Horsham
District
Council

Gatwick Northern Runway Project DCO (Project Reference: TR020005)

Deadline 8 Submission (7 August 2024)

Overview

Hotel, office and multi-storey car park on Car Park H

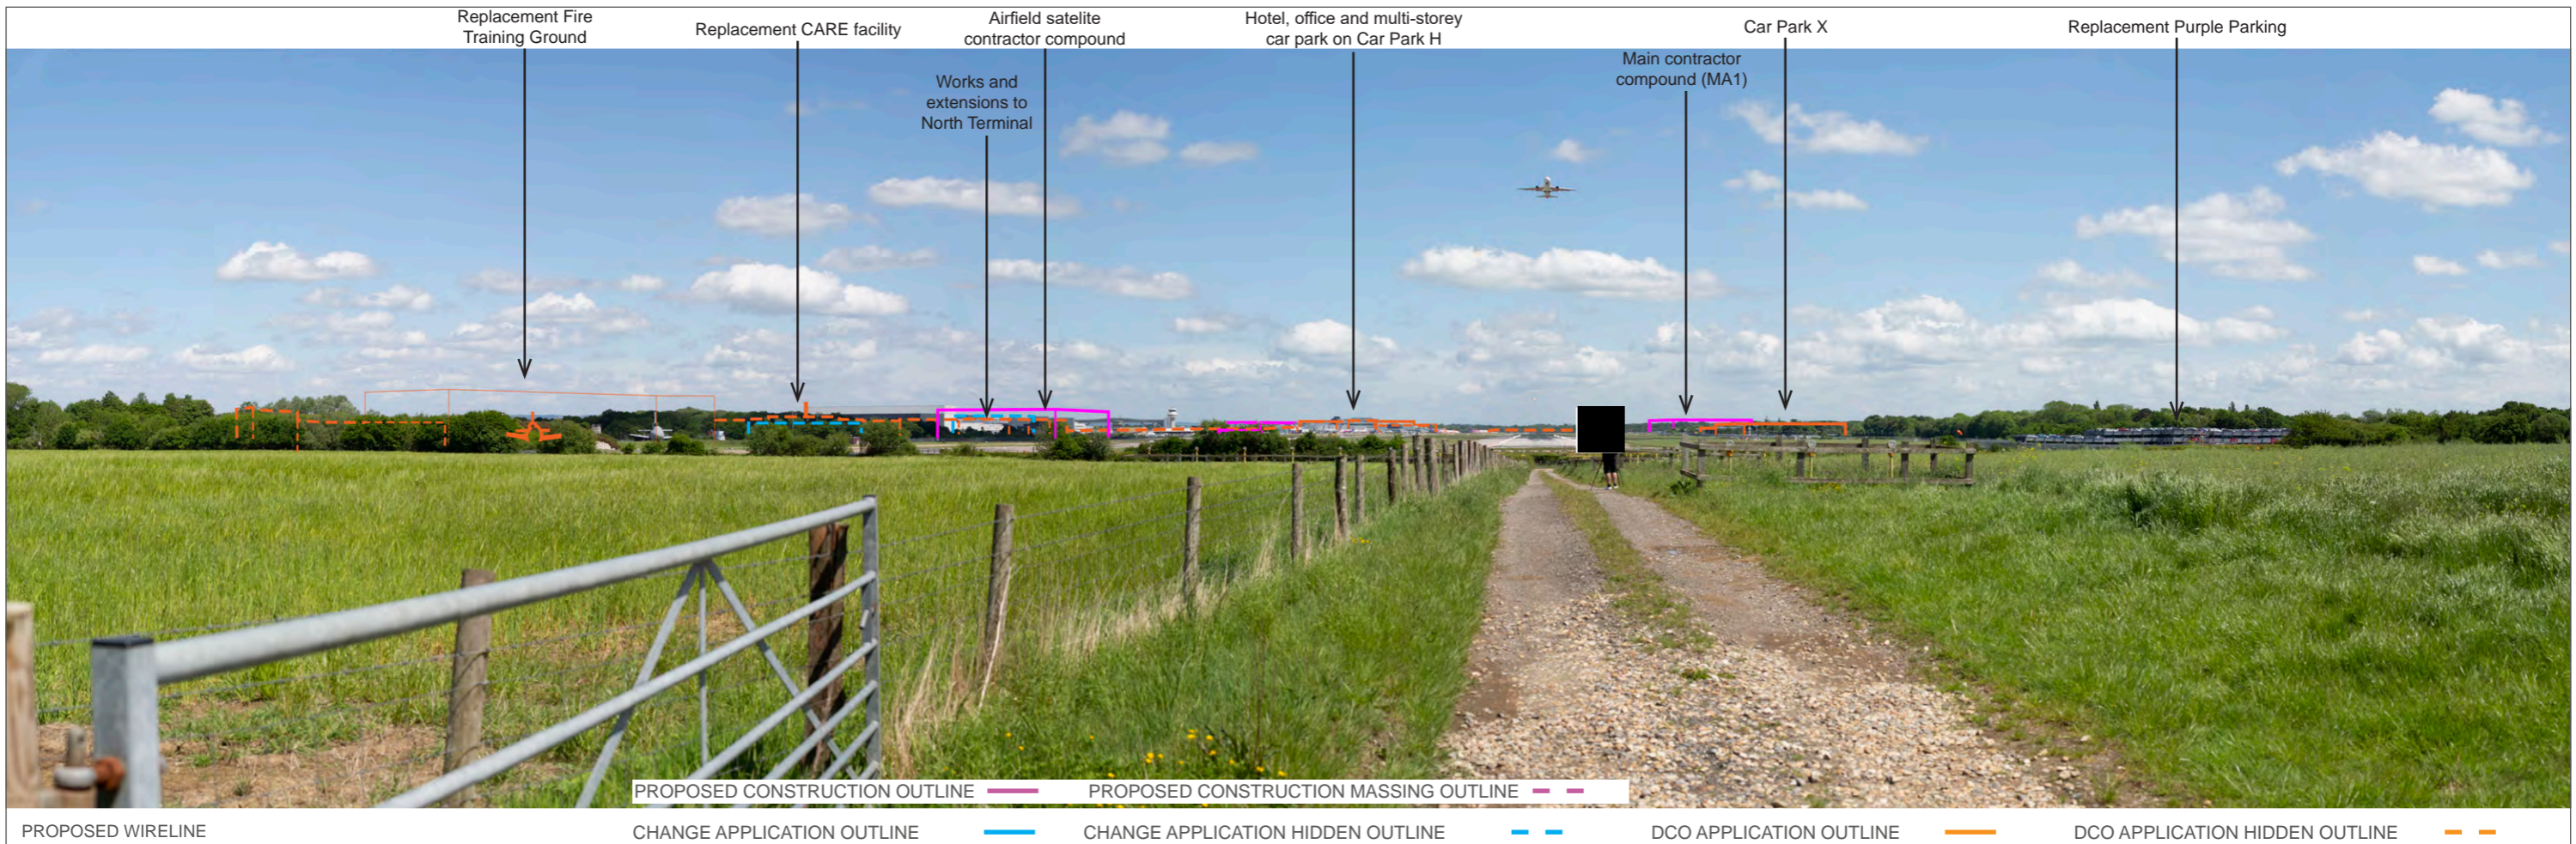
- (ii) There has been discussion of other sites (sensitive due to underground services) including the area for new hotel offices and multi-storey carpark H (Works site number 28) which is still not identified within the revised WSI despite the Authorities written request for this to be so. While it was acknowledged that this area only had a limited amount of services within the present car park and considering its early construction there is a potential of surviving archaeological deposits. It is still recommended that some archaeological work is undertaken within this area (perhaps in a staged approach, with initial low level of trenching to assess survivability and then wider if there is good survival.)
